CITY OF ALBUQUERQUE

RE: **Winrock Road Town Center**
2100 Louisiana Blvd NE
Drainage Master Plan- Drainage Implementation Plan
Engineer's Stamp Date: 5/16/19
Hydrology File: J19D058

Based on submittal received on 5/17/19, the Drainage Implementation Plan cannot be approved for Site Plan for Building Permit until the following are corrected:

EXHIBIT 1

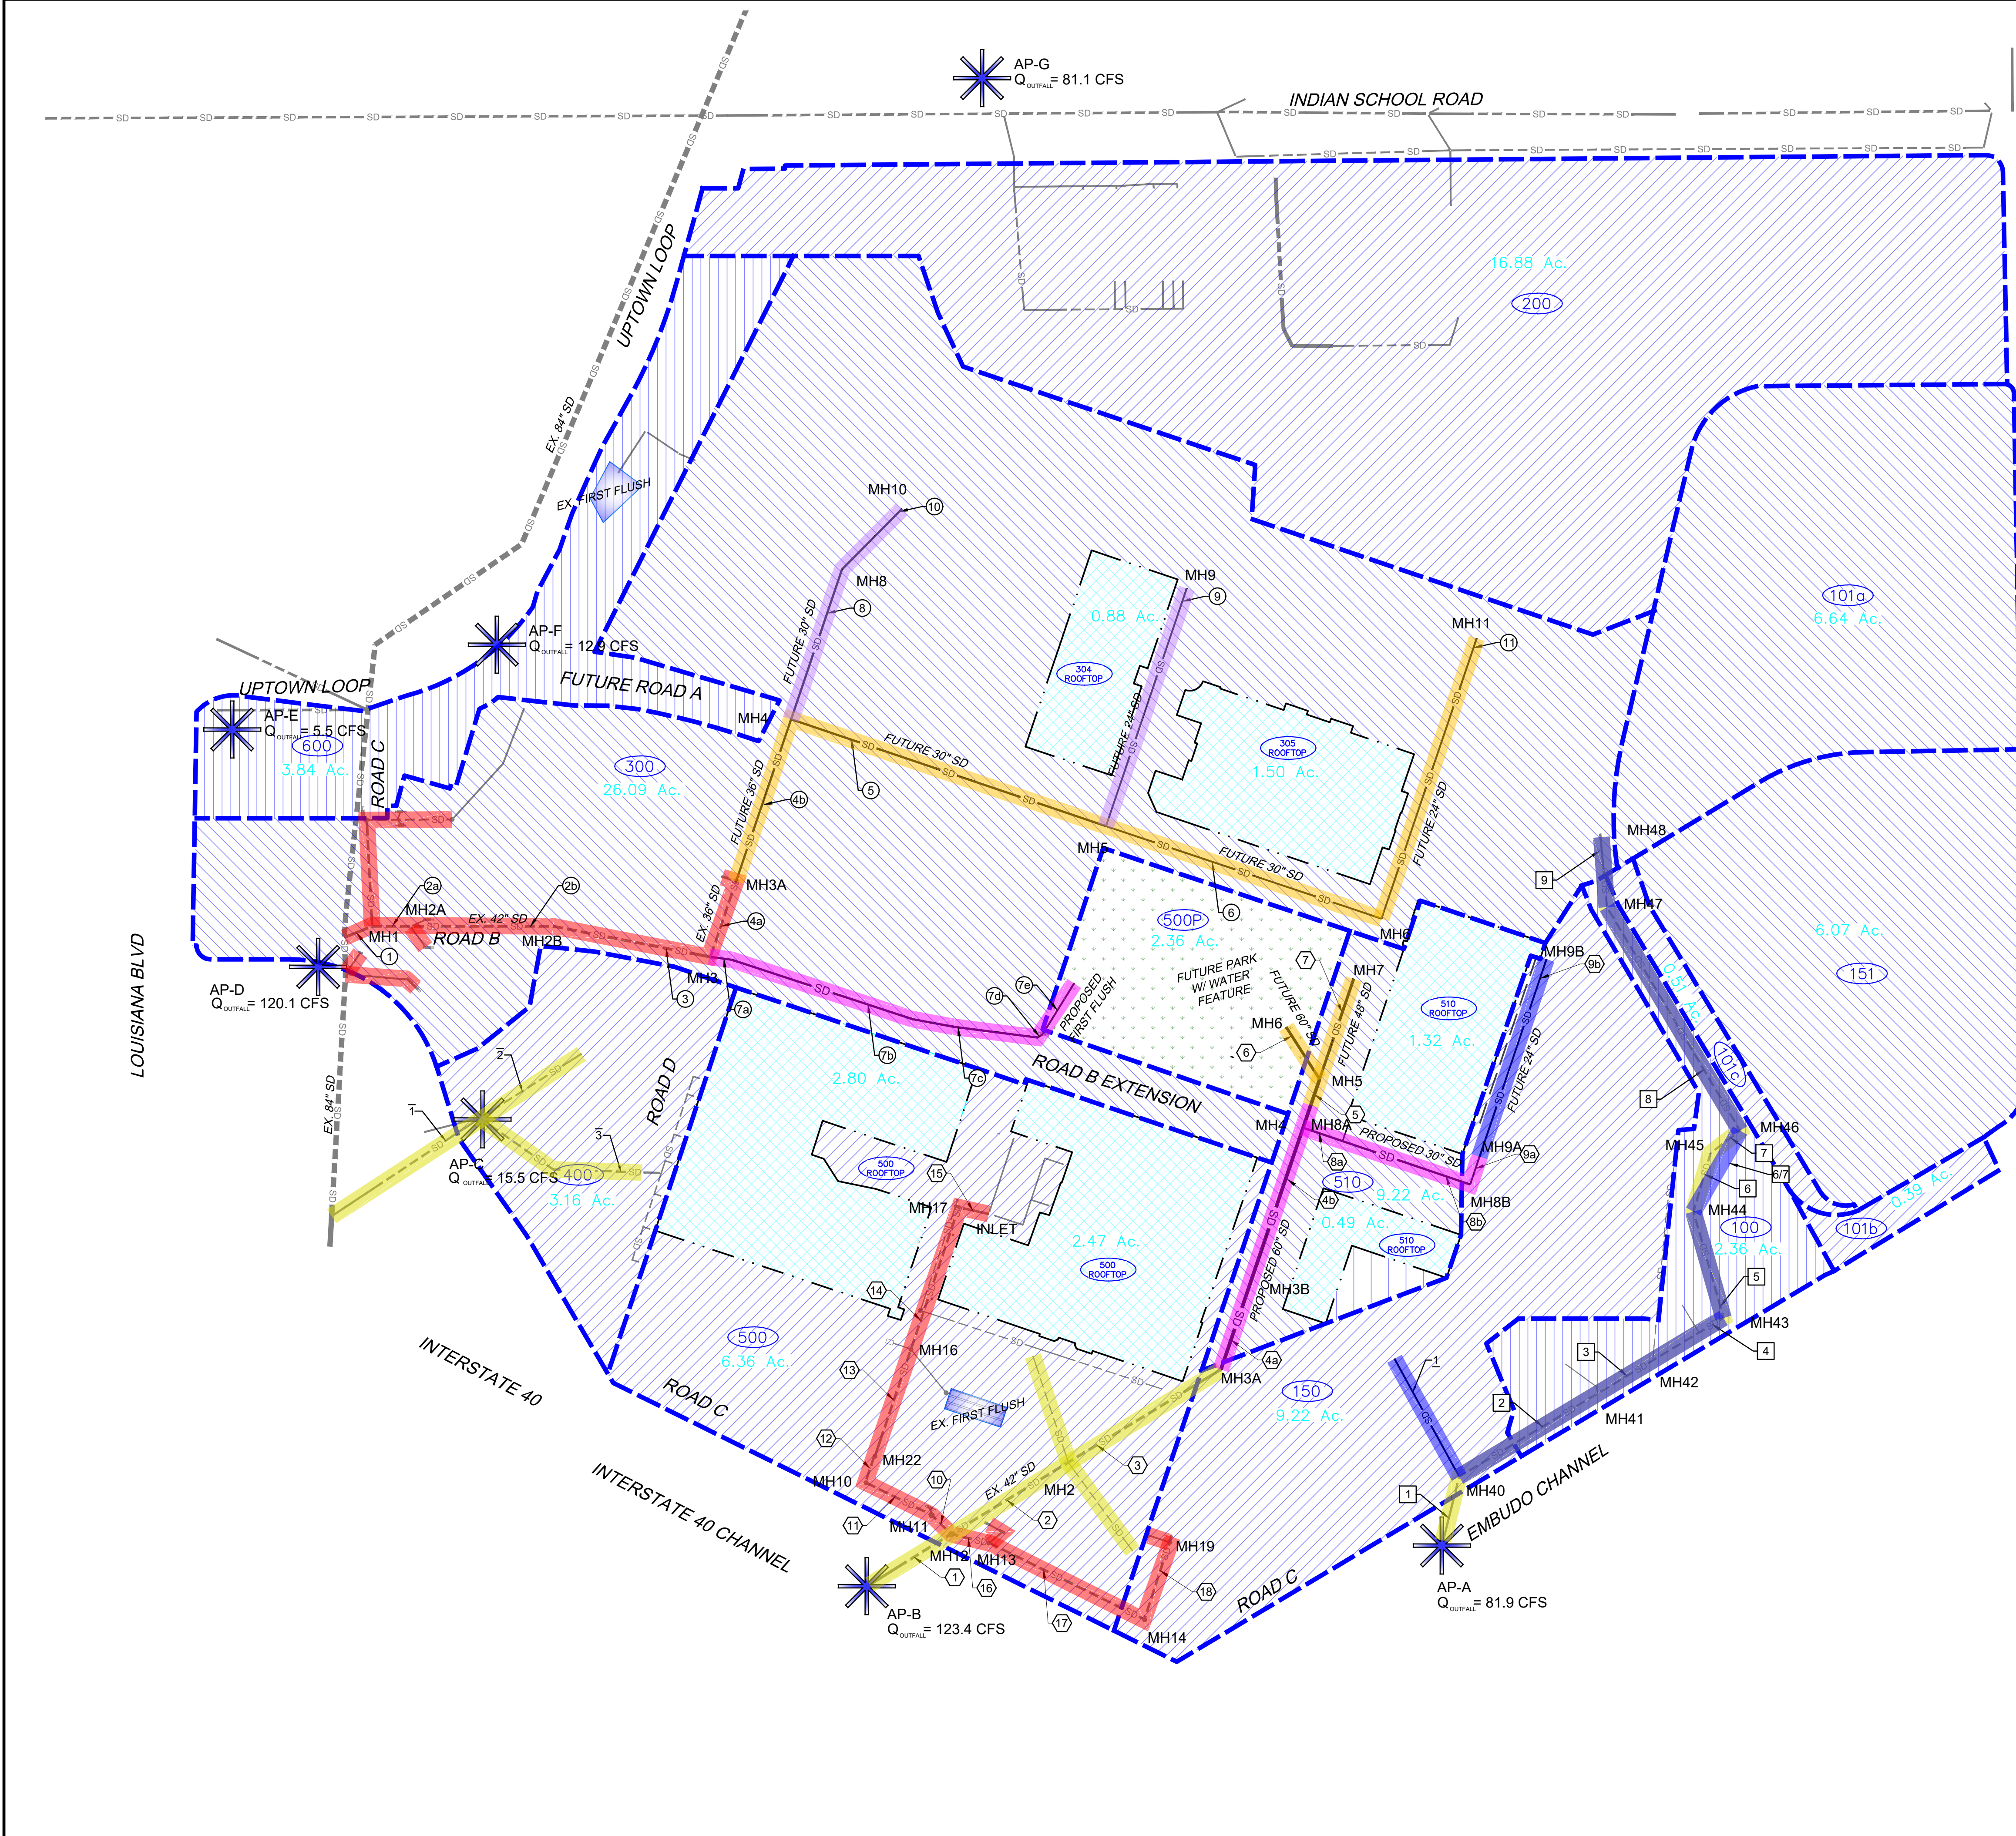
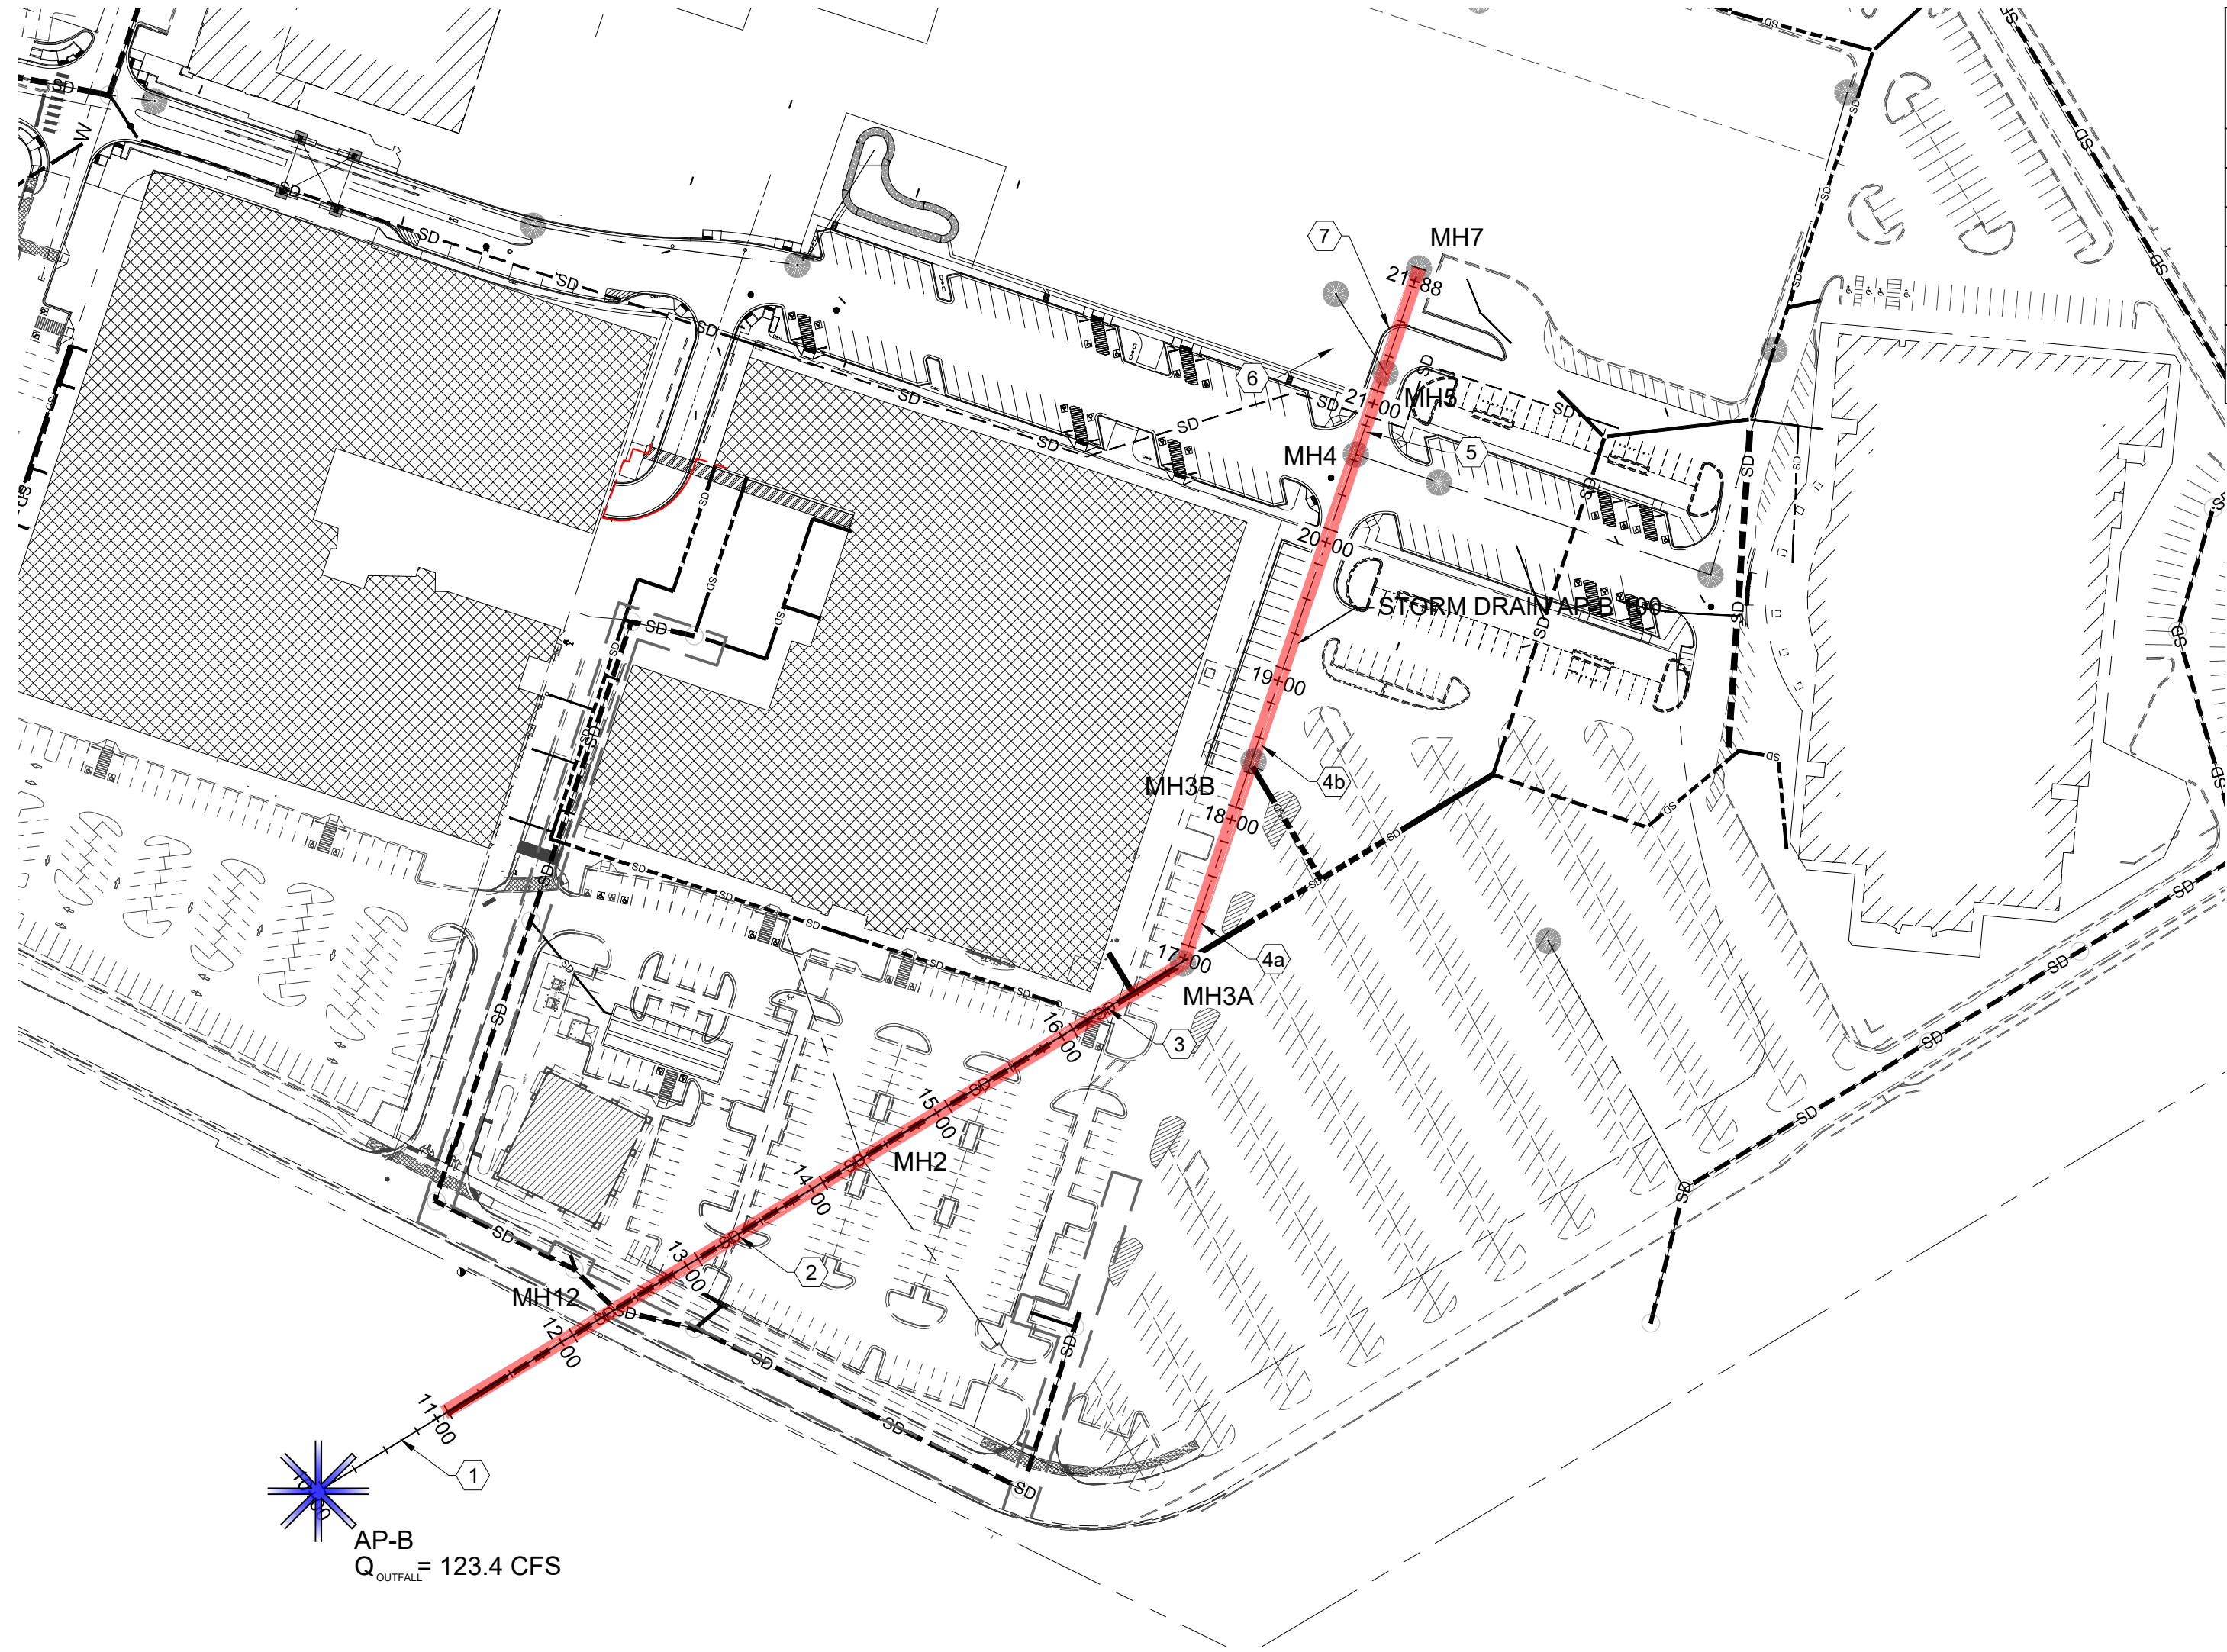
1. Exhibits 1-8 minor remarks:
 - a. The existing (Pre-DMP) pipes should all be RCP, not HPPP; this will affect the friction slope.
 - b. On Exhibit 2, pipe 2 appears to be mislabeled in plain view.

2. Because these corrections are minor, the administrative resubmittal fee of \$40 may be used. Please include a copy of this letter when resubmitting in order to receive the reduced fee.
3. For Information. Include Exhibit 1 in the DRB Master Site Plan. Please check that the phases match the Architect's phases. The remaining exhibits (2-8) can remain in the DIP, so long as the master summary table is provided on Exhibit 1.
4. For Information. Prior to Work Order for each phase, a detailed drainage report will be required to detail many of the hydraulics shown in the DIP as well as address all grading and drainage criteria per the DPM, such as storm water quality and surface flow hydraulics.

WINROCK TOWN CENTER	
PHASE B INFRASTRUCTURE IMPROVEMENTS	
TITLE: STORM DRAIN AP-B 400 & 500	
Design Review Committee	City Engineer
Ms./Day/Yr.	
Ms./Day/Yr.	
Last Update	
City Project No.	
4553.90	
Zone Map No.	J-19-Z
Sheet	Of
EXHIBIT 4

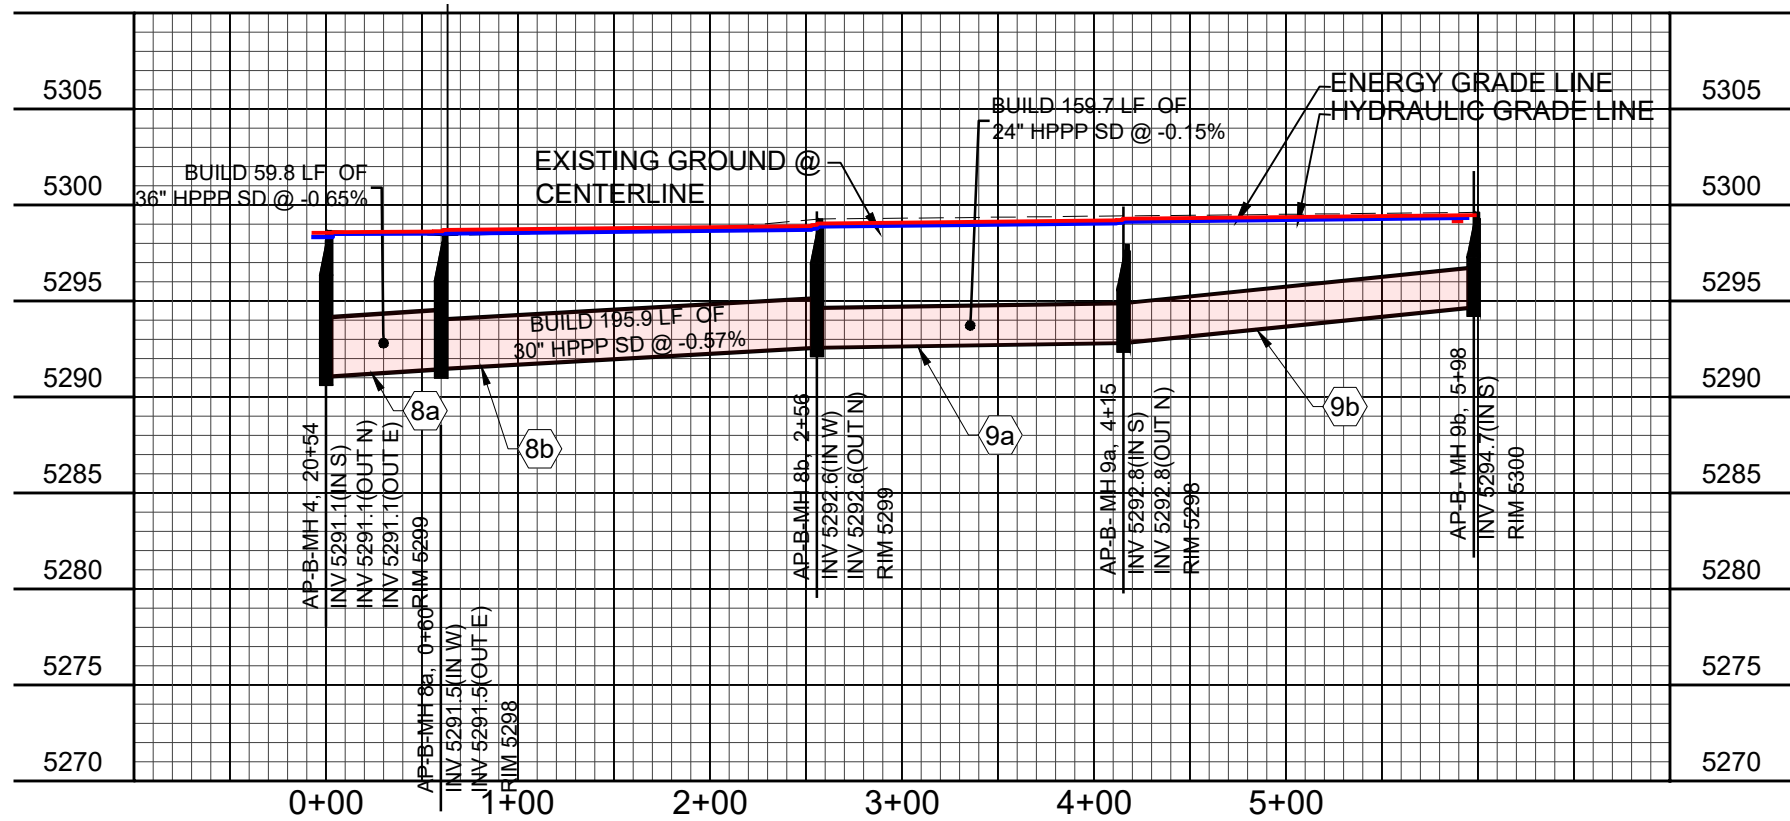
- iii. pipe 16 Q is 14.3cfs, but is shown as 22cfs on the exhibit 1 table.
 - d. On Exhibit 4,
 - i. pipe 6 is called out as 48" in profile and on the exhibit 1 table, but is 36" in the table;

- ii. pipe 6 Q is shown as 24cfs on the table, but is shown as 51cfs on the exhibit 1 table.
 - e. On Exhibit 5, pipe 7a-7e are called out as 30" in profile, but are 24" in the table and 42-30" on the exhibit 1 table
